RAVENSWORTH OPEN CUT

RAVENSWORTH OPERATIONS FINAL LANDFORM MODIFICATION – RESPONSE TO SUBMISSIONS

**Ravensthorpe Operation Modification 2 (09_0176 MOD2)
Review of Environmental Assessment**

HB 1431 10 Ravensworth Mod - Landform Sections Combined (9/09/2014)

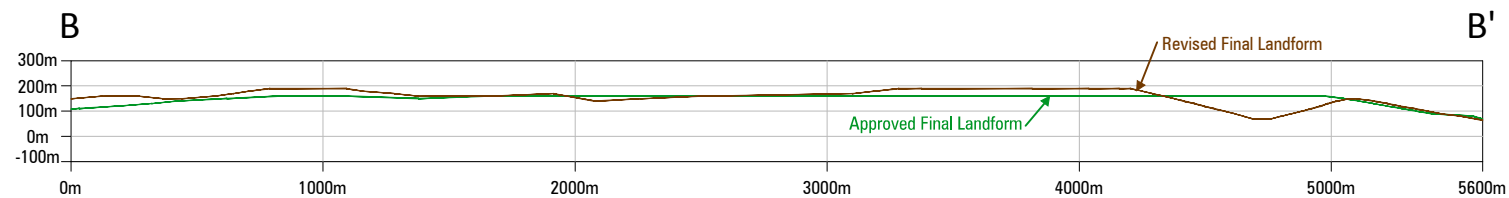
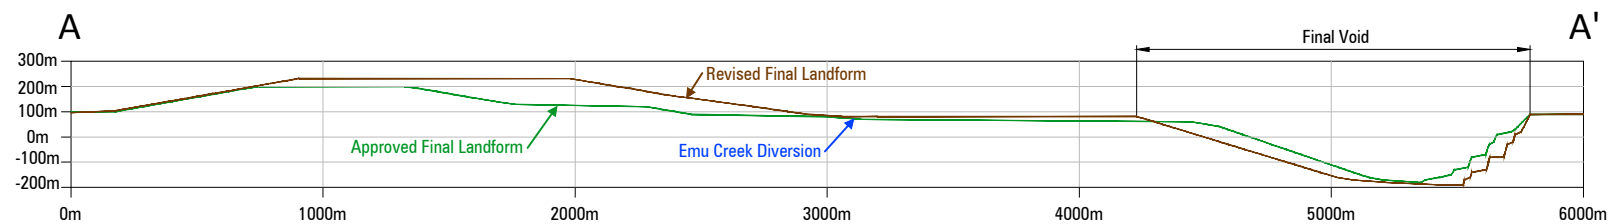
The Office of Water notes from Figures 3 and 4 of the EA that the revised final landform would result in changes to the size and shape of the final void. This may have implications for ongoing groundwater inflows to the void which is predicted to act as a groundwater sink. The commitment to continue to manage operations in accordance with the Ravensworth Operations Water Management Plan is noted. The Office of Water requests that the plan be amended to incorporate the modification, including an evaluation of the impacts of the modification on long-term groundwater inflows.

Revised Conceptual Final Landform

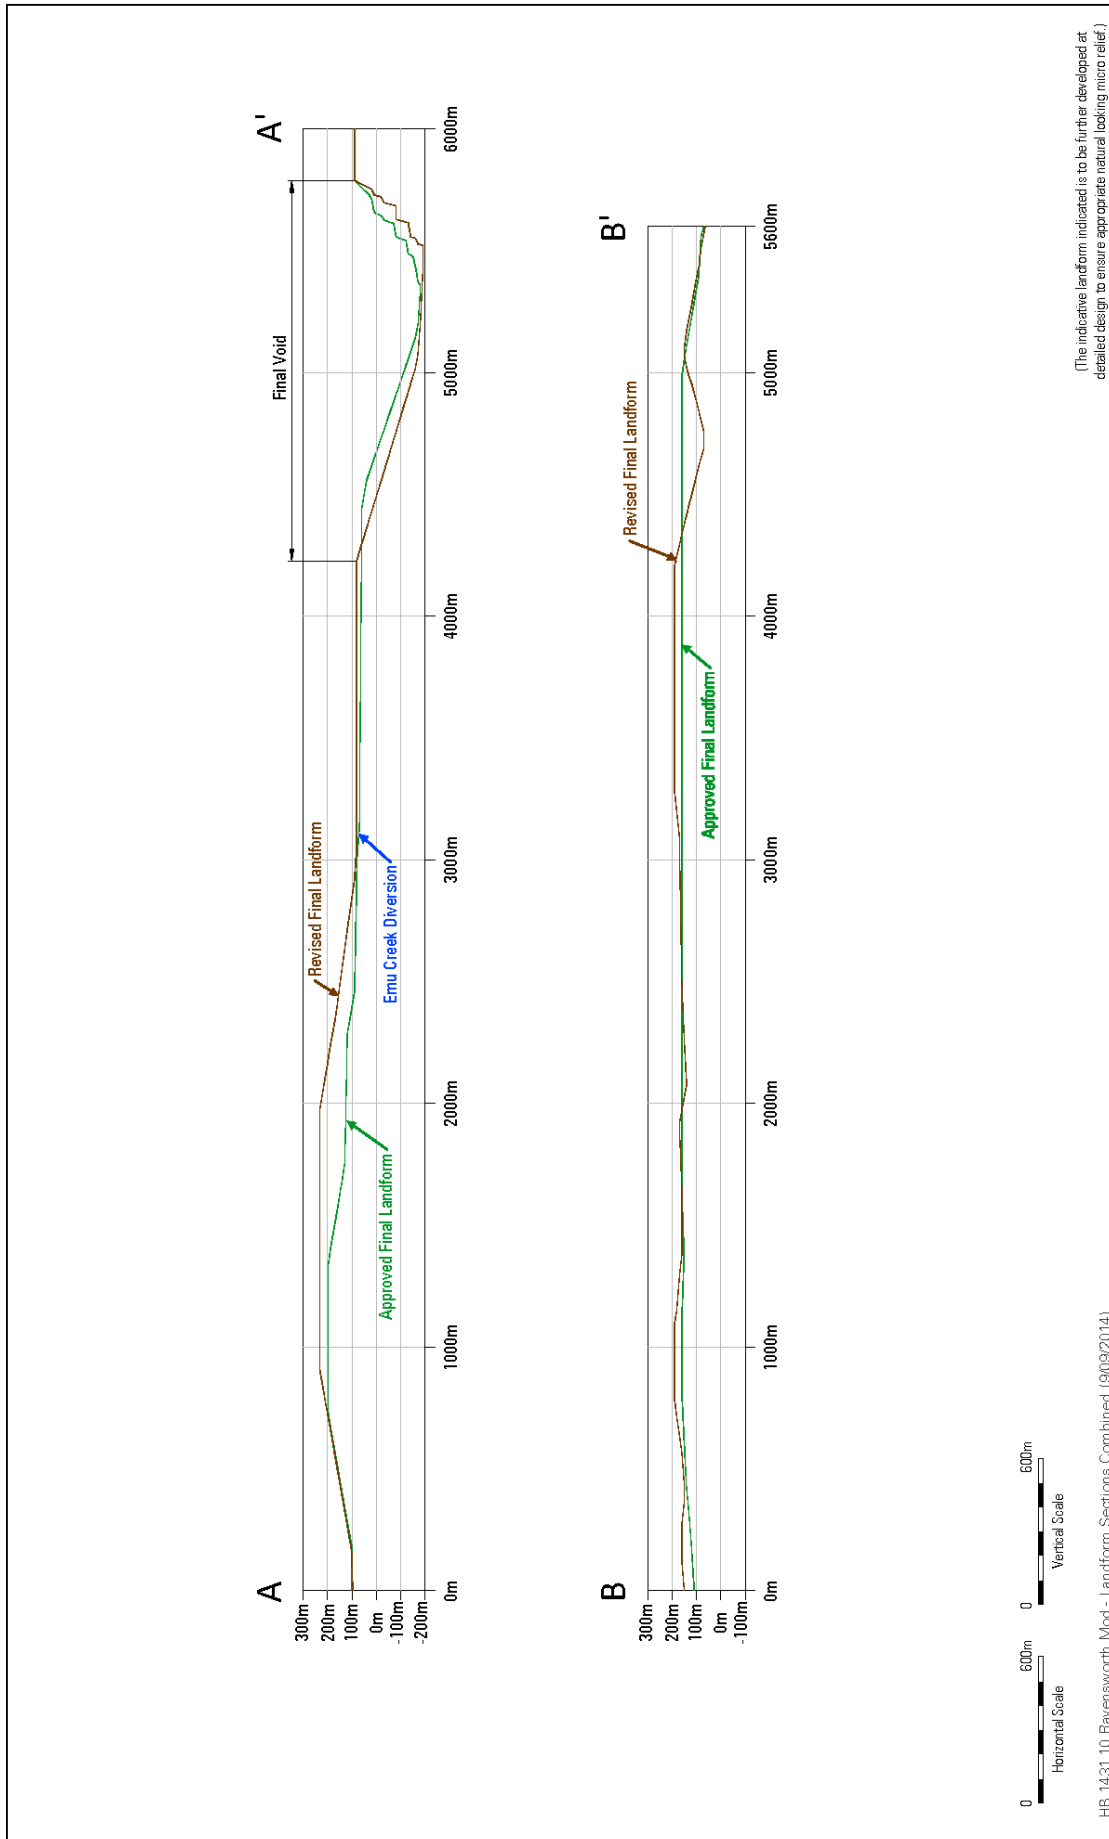
- Justification that a topographically diverse landform is not practical within current emplacement height restrictions;
- For each pit, justify the final void design and future use. There should be no increase in the number or size of final voids;
- Justify the need for water management (e.g. contour drains and sediment detention basins); and
- Detail the environmental net benefit of the proposed final landform design.

As depicted conceptually the Modification EA (Figure 3) has identified a small increase to the surface area of the final void. Following a meeting between representatives from DRE, Ravensworth Operations and Hansen Bailey on 6 November 2014 and to address the issues DRE identified in their correspondence dated 14 November, Ravensworth Operations has since completed additional mine planning in order to develop a landform with a void consistent to that approved.

As a result of this additional mine planning, an alternative Revised Conceptual Final Landform has been developed for the Modification (see **Figure 1**). In addition, a section line has been developed to provide a comparison between the alternative Revised Conceptual Final Landform with regard to the existing approved final landform (see **Figure 2**). This alternative Revised Conceptual Final Landform effectively ensures that the Western OEA north of the future Emu Creek Diversion remains as currently presented in the Modification EA however the landform south of the future Emu Creek Diversion will be constructed consistent with the landform currently approved (see **Figure 1**).

The alternative Revised Conceptual Final Landform ensures that the visual benefits of the Modification are maintained without altering the size, catchment area, maximum predicted water level or position of the approved final void. Given this outcome the final void is anticipated to remain as a groundwater sink as described in the Ravensworth EA.
